LOCAL AUTHORITY PLANNING OBSERVATIONS

APPLICATION NO: 3/2024/0893
DECISION DATE: 06 December 2024
DATE RECEIVED: 04 November 2024

DEVELOPMENT PROPOSED: EIA scoping request for a proposed alternative temporary park and ride and heavy goods vehicle (HGV) marshalling area.

AT: land off Pimlico Link Road

FIGURE 2

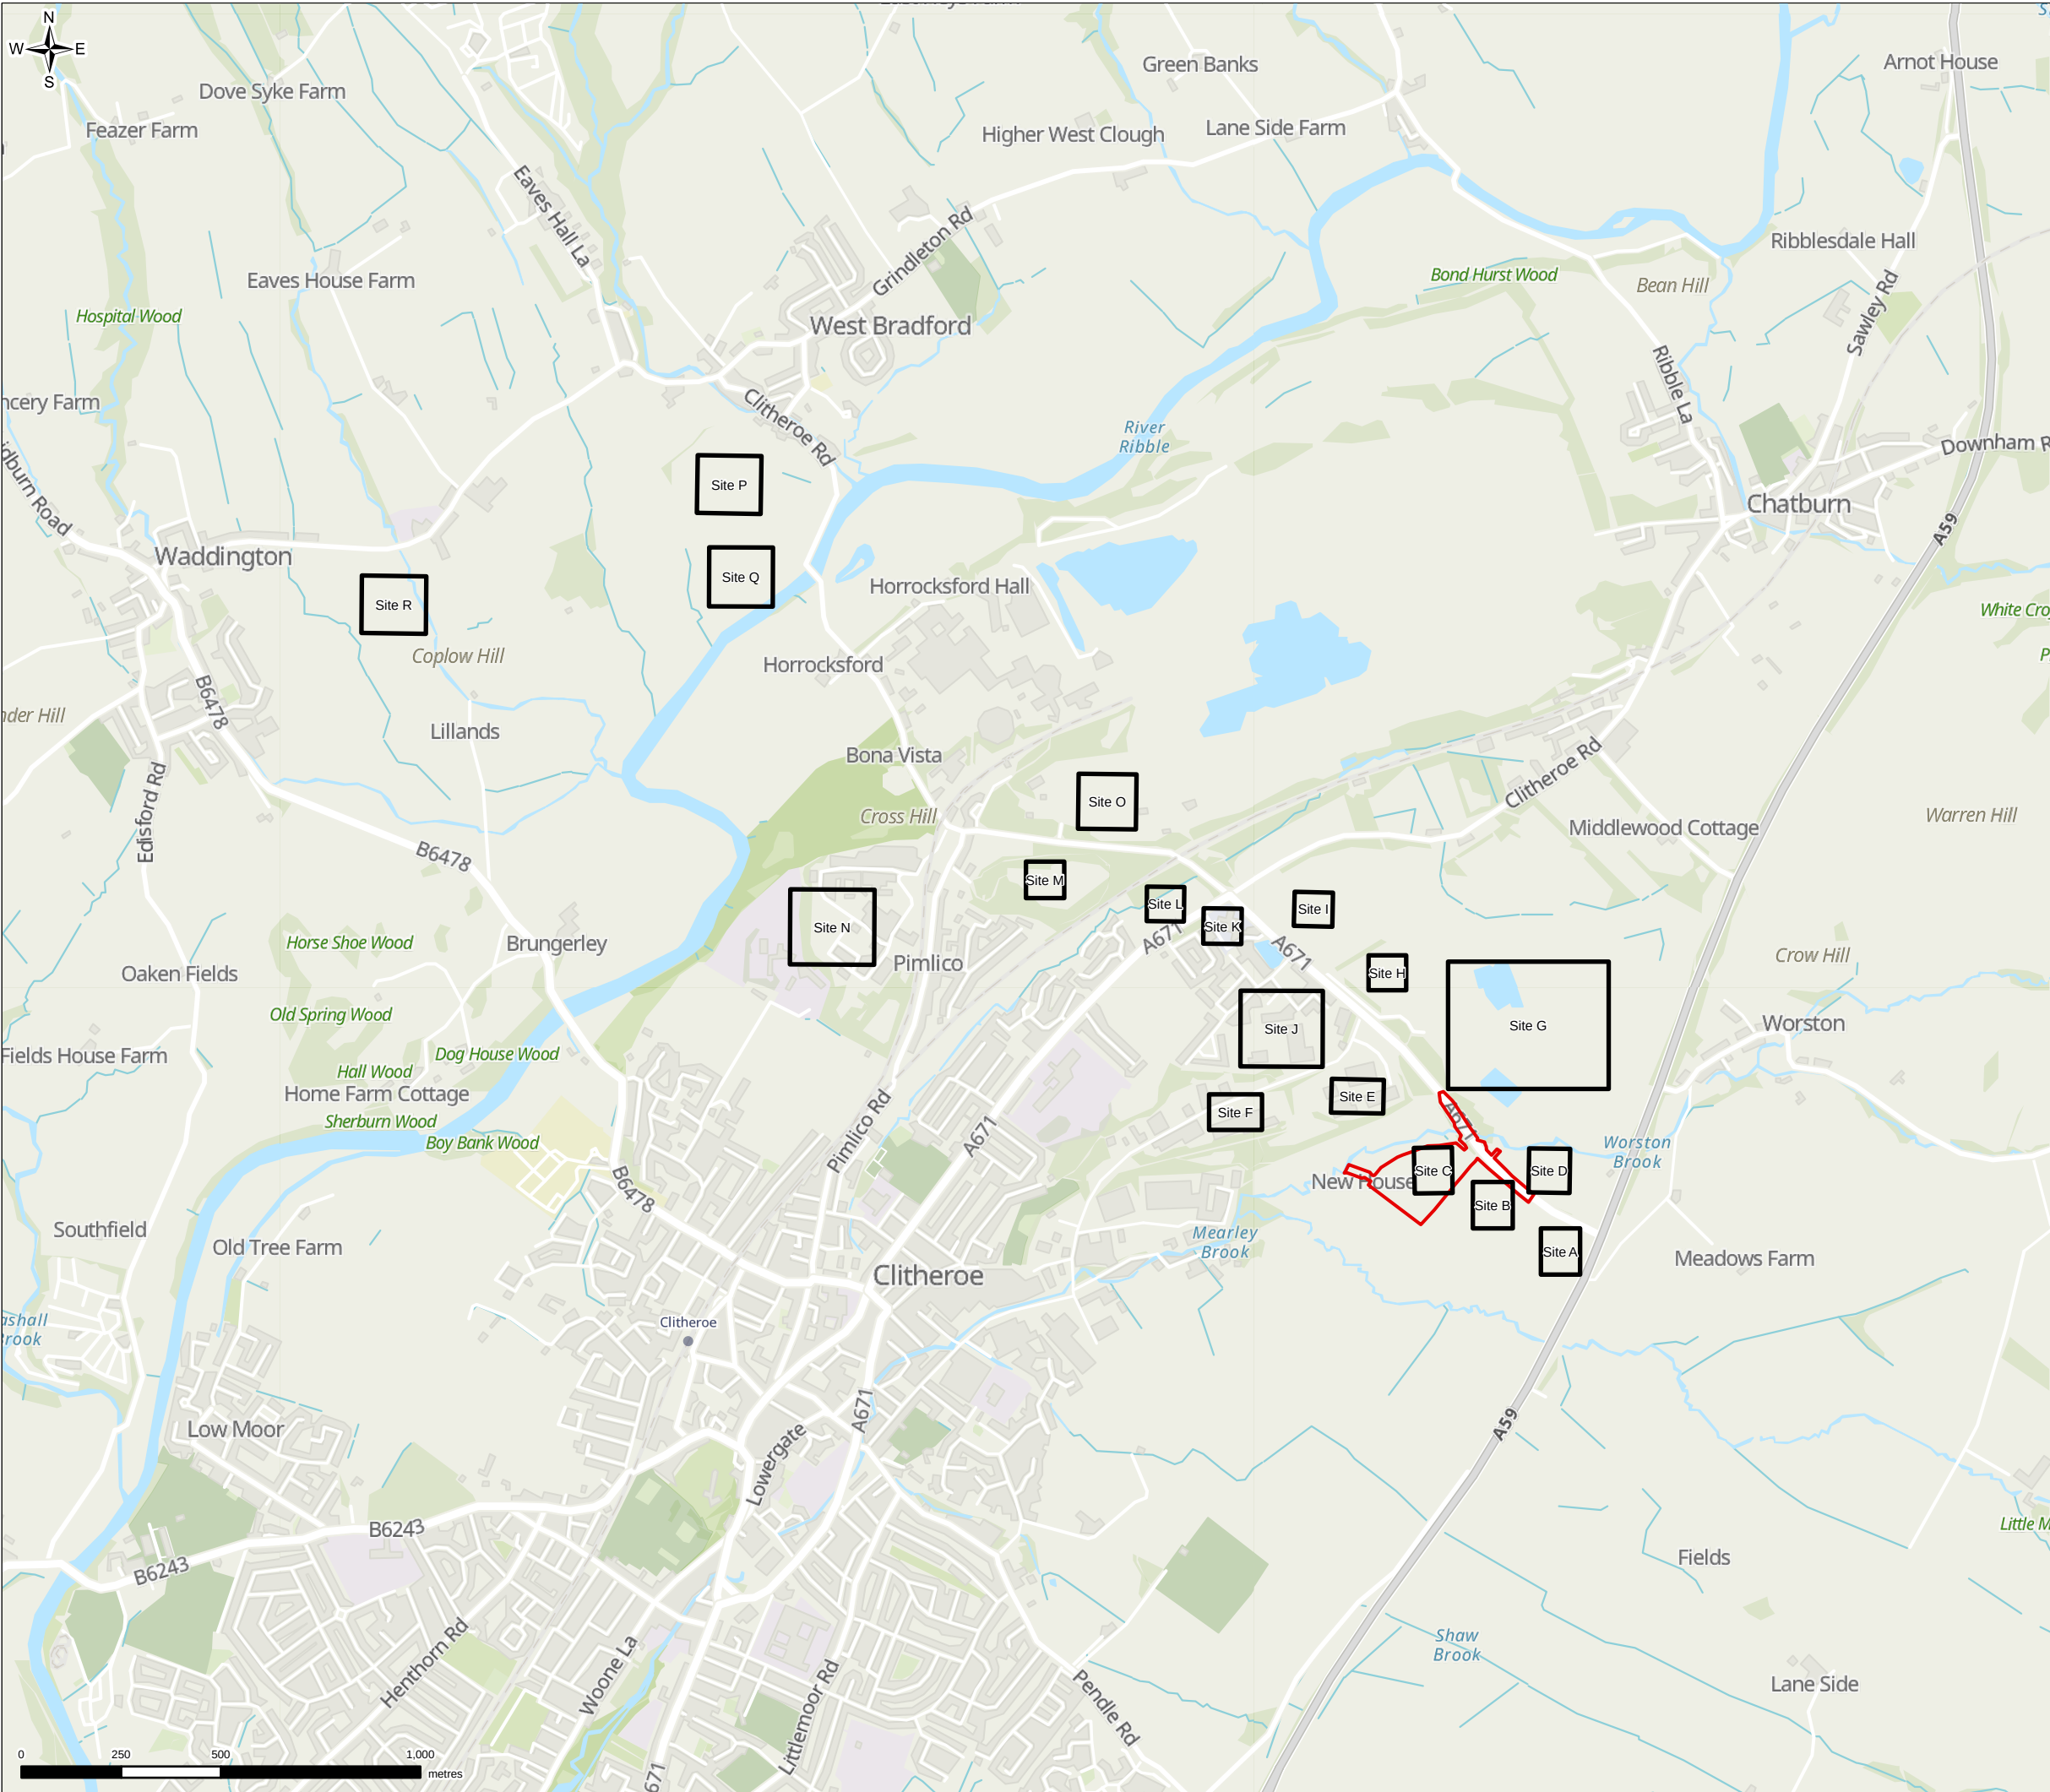
With respect to section 2.4 and reasonable alternatives, it is noted that some of the alternatives are discounted for reasons of scale and it is therefore considered that the ES should sufficiently detail why separating the park and ride from the HGV marshalling area would not be feasible, to justify discounting them.
